MMO Reference: DCO/2020/00005
Planning Inspectorate Reference: EN010078
Identification Number: 20024119

Planning Act 2008, Scottish Power Renewables, Proposed East Anglia Two Offshore Windfarm Order

Deadline 1 Submission

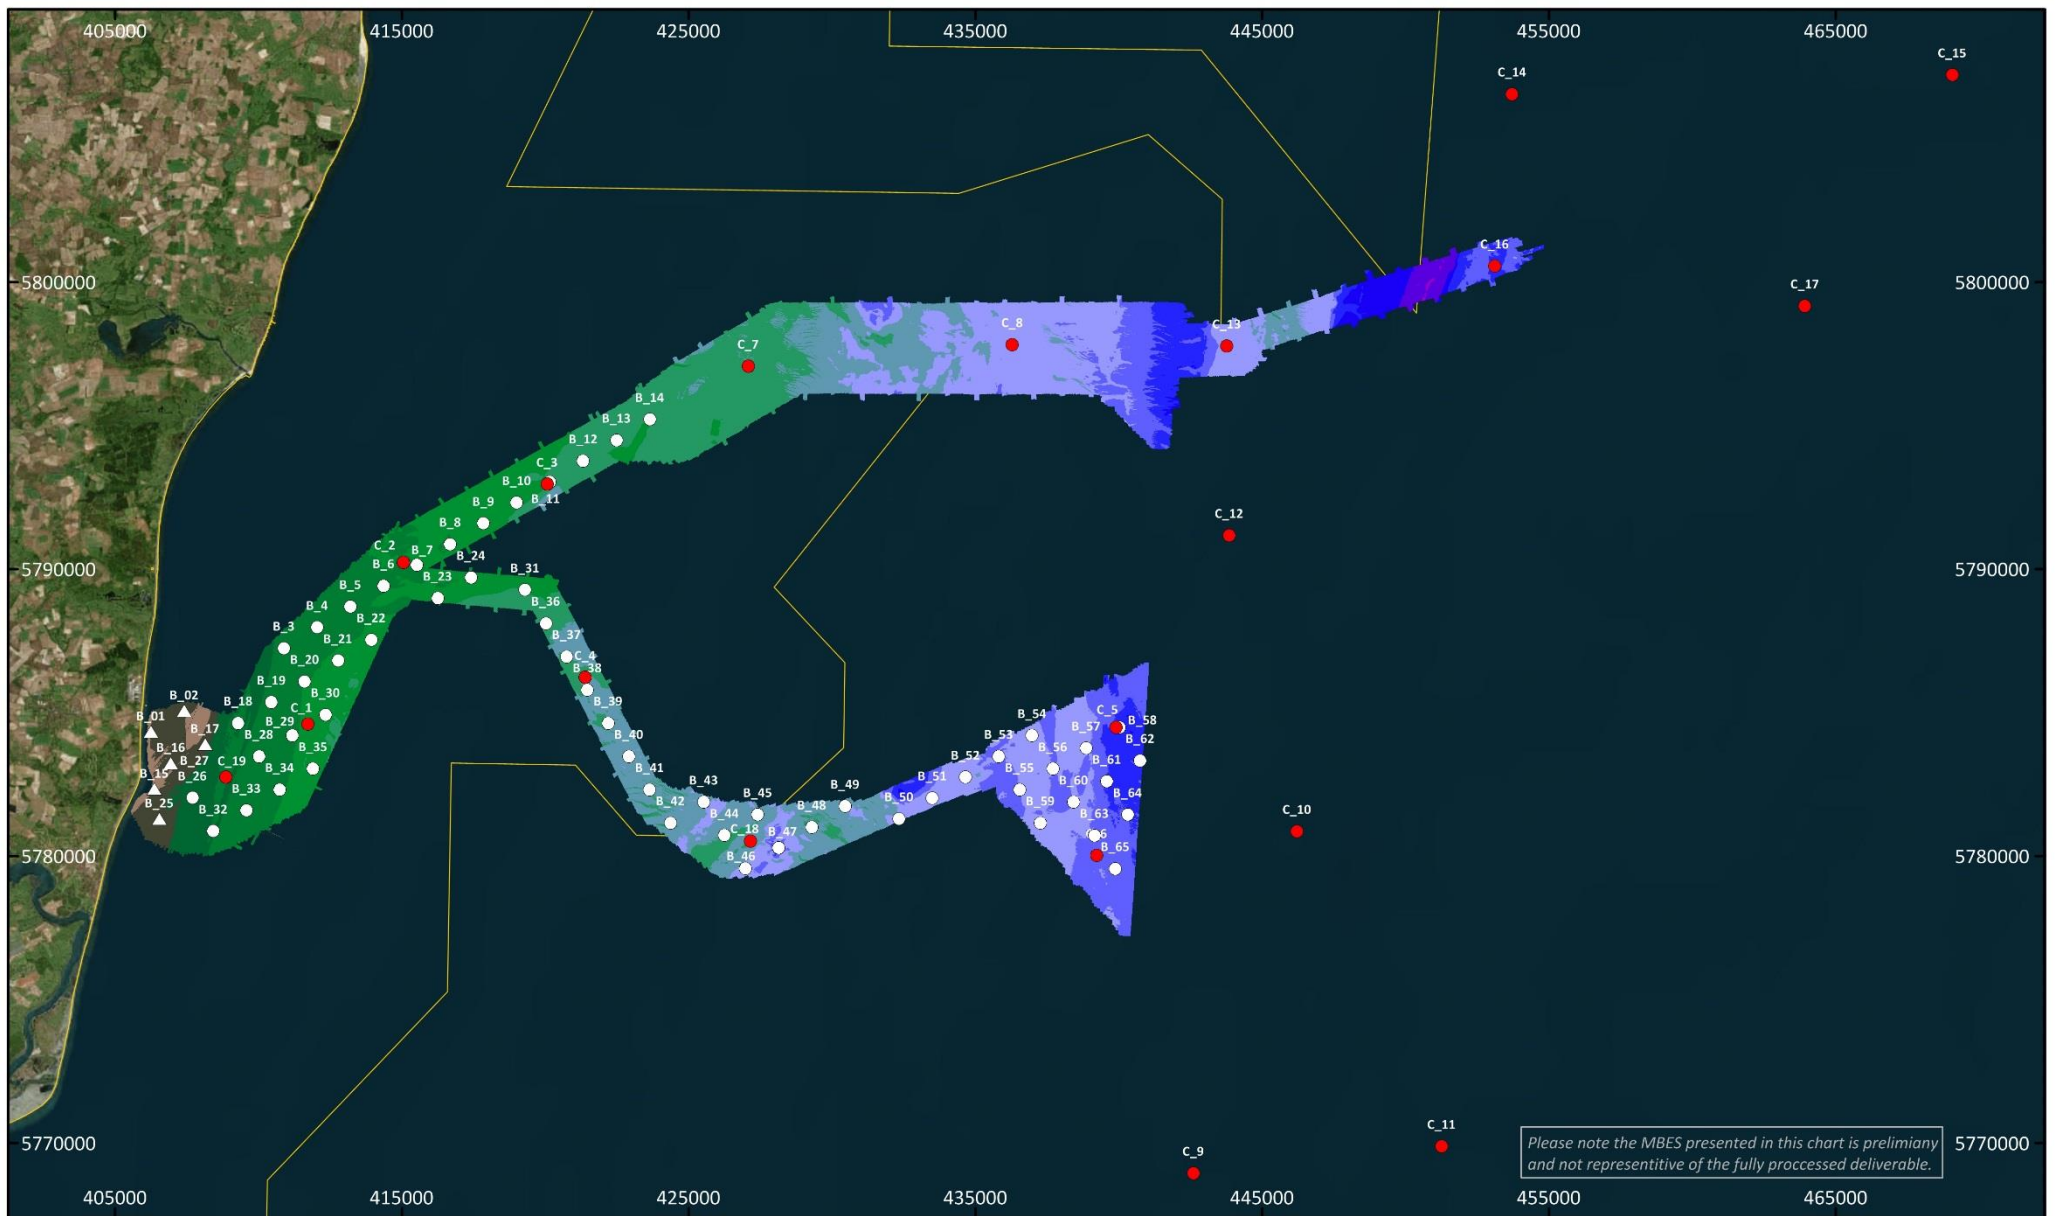
1.12 Upon reviewing Chapter 09 the MMO highlighted insufficiencies which included highlighting the lack of findings from the side-scan sonar, advising that Hamon grab samples are not suitable for the collection of contaminant samples. The action of the Hamon grab mixes the sediment, which could result in the release of adsorbed contaminants and cause the sample to be unrepresentative of the actual contaminant load.

1.13 Further, MMO noted that no benthic monitoring was proposed. The MMO recommended that grab samples should be collected to monitor the effect of turbine installation on sediment composition and benthic communities. This would allow the predicted effects on benthic ecology to be confirmed or otherwise.
